| Application Ref: | 3/2021/0304 |  Ribble Valley Borough Council www.ribblevalley.gov.uk | |
| DELEGATED ITEM FILE REPORT: | | Decision | Approval |

| Development Description: | Proposed first floor side extension over existing playroom, single storey rear extension and porch to the front. |
| Site Address/Location: | Bridge End Cottage, Rimington Lane, Rimington. BB7 4EA |

● **PLANS as PROPOSED**

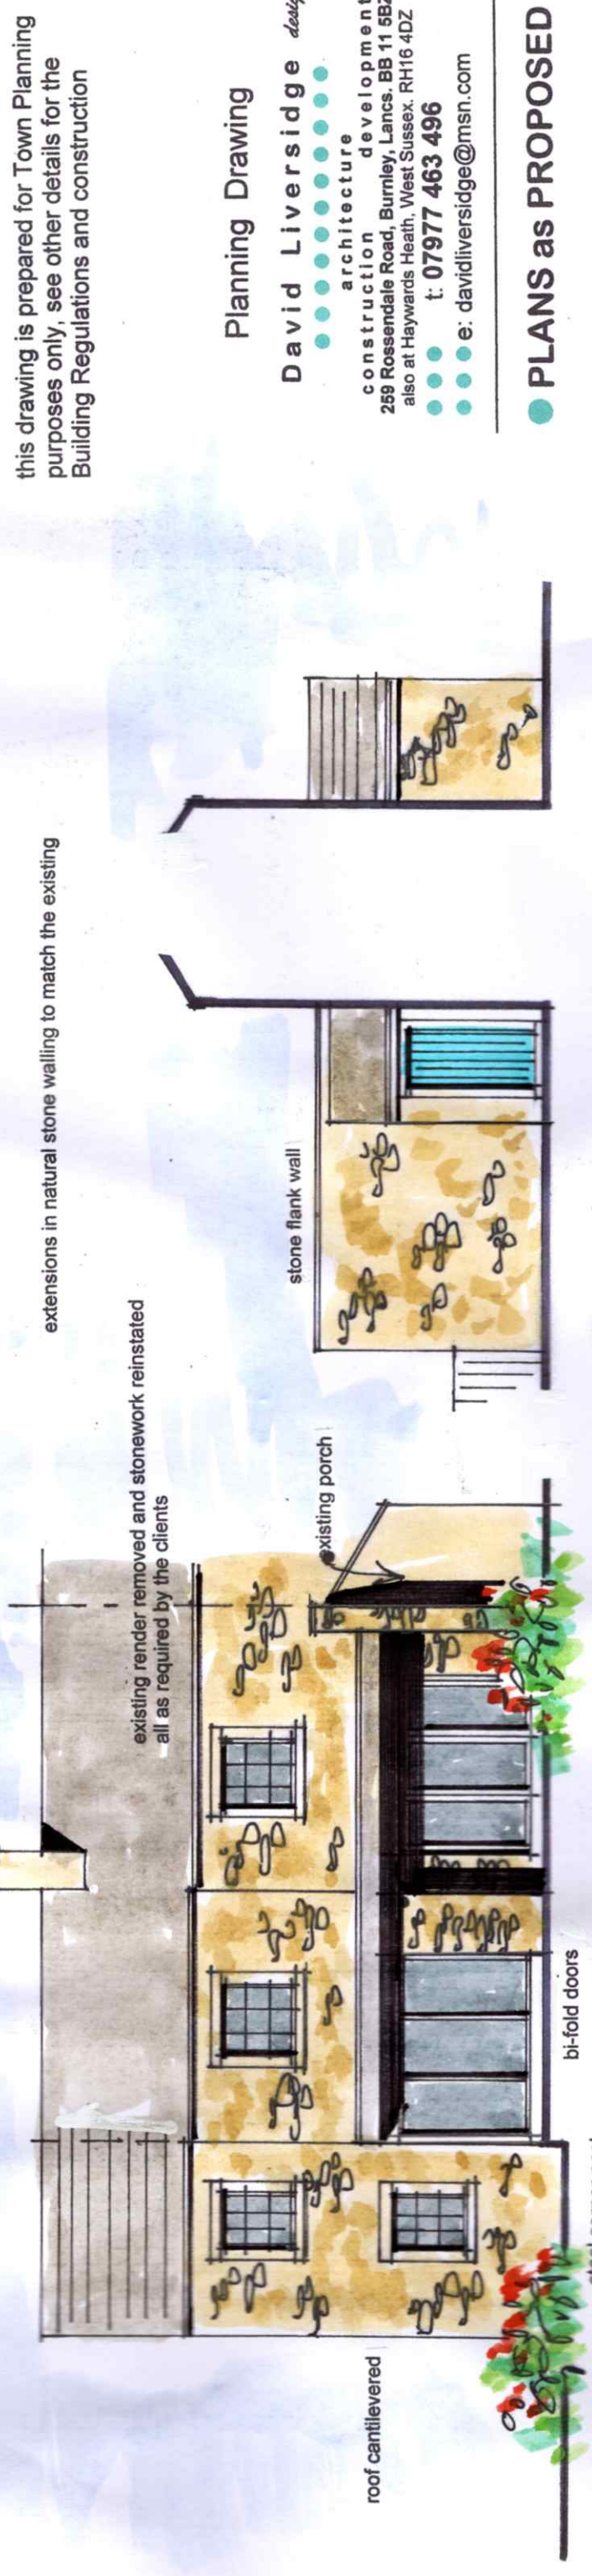
The proposal will incorporate several windows to the property's Northern front elevation which will be sited on the proposed front porch and on the property's ground and first floor levels. These windows will not compromise existing privacy levels in as much that they will allow similar views to those provided by the property's existing ground and first floor level windows.

The proposed works to the property's Southern rear elevation include a set of bi-folding doors and full length windows which will form part of the single storey extension and an additional first floor window all of which will allow partial views into the each of the neighbouring rear gardens. These areas are already viewable from the property's existing ground and first floor level windows therefore it is not anticipated that the proposed windows will provide any new opportunities for overlooking.

The proposed first floor extension will have an equal roof pitch height to that of the main property and as such will have a noticeable visual presence however given that the extension will be set back from the front elevation of the main dwelling within an isolated cluster of buildings it is not considered that the proposed works would have any harmful impact upon visual amenity.

The proposed rear extension will be subservient to the primary dwelling in as much that its roof height will be set well below the roof height of the main property. The extension will incorporate a flat roof design with a modest outwards projection of 3.3 metres and as such will not be an over dominant feature. The rear extension will have a width of 8.2 metres and will be viewable from Rimington Lane therefore the proposed works will have some visual impact however it is not considered that the extension would have any undue impact upon visual amenity.

The proposed works include the addition of a porch to the front of the main property which will measure 2 x 3.8 metres with an eaves and roof height of 2.6 and 3.7 metres respectively. Extensions to the front of a main property may not always be appropriate due to their increased visual impact however in this case it is not considered that the extension would be of detriment to visual amenity in as much that the porch will be set back from the main road within an isolated group of dwellings and will not be an over dominant feature in terms of size.

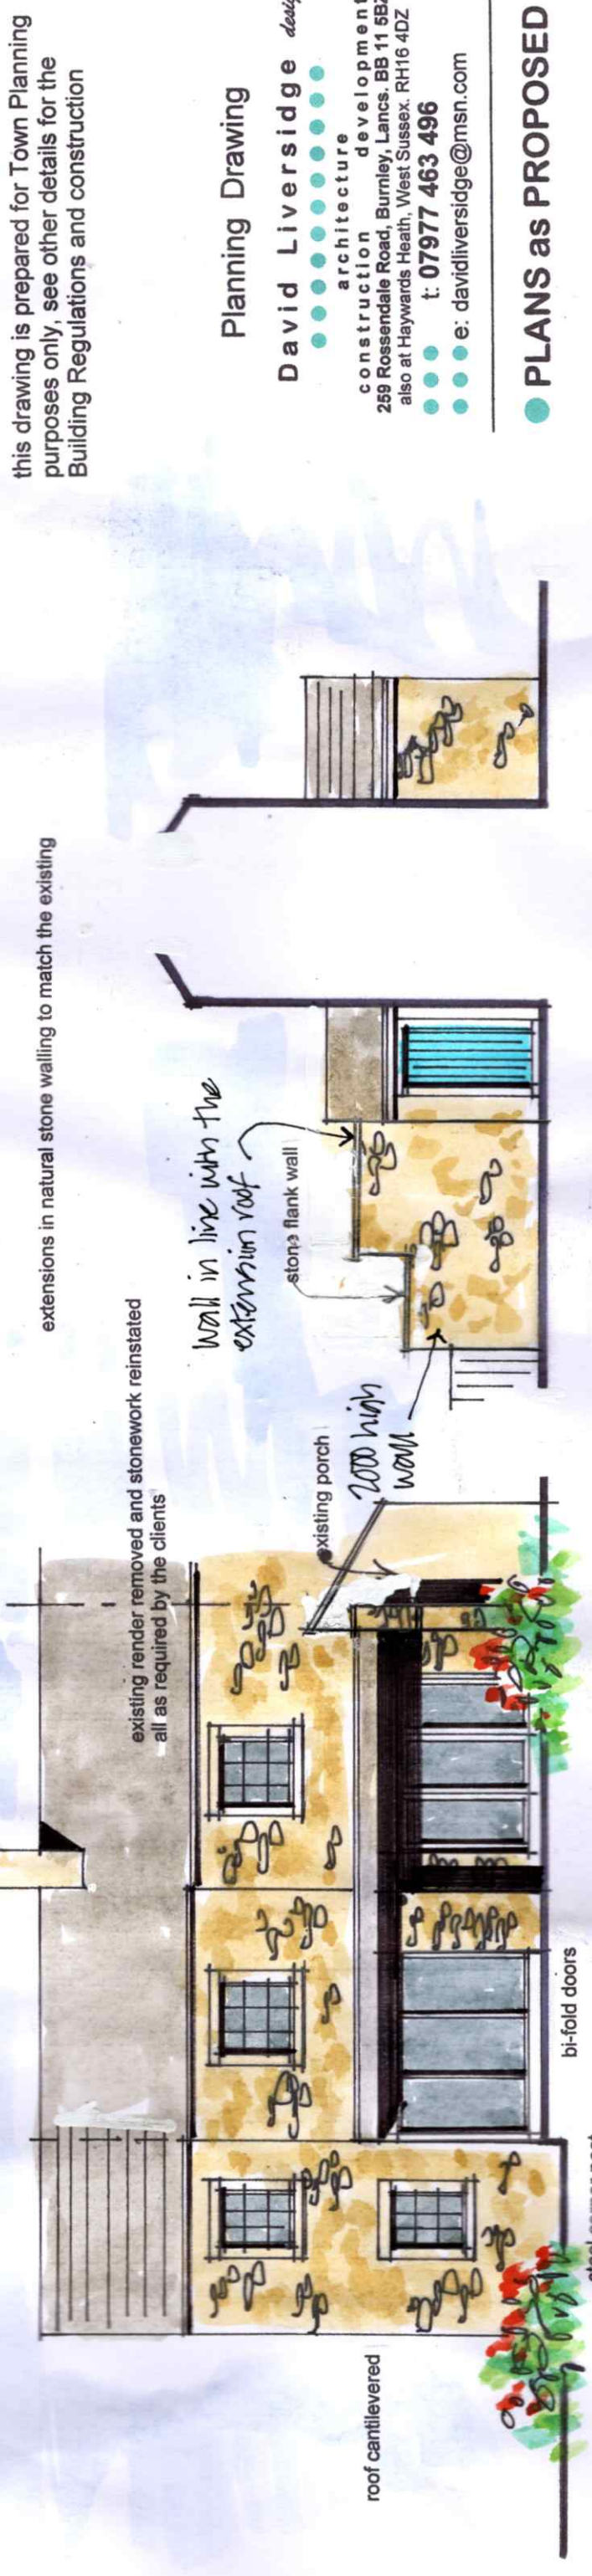
The proposed rear extension also includes a window on its Western side elevation which will face towards two ground floor windows on the neighbouring property of Bridge End Barn. This window would more than likely have led to an unacceptable loss of privacy however the applicant has since submitted an amended plan to address this issue through incorporating an obscure glazed window.

The originally proposed boundary wall stood at 3.7 metres with a continuous ridge line. This structure would more than likely have led to an unacceptable level of overshadowing in the rear garden of Bridge End Farm however the applicant has since submitted an amended plan to address this issue through reducing the height of the wall by way of incorporating a stepped down design.
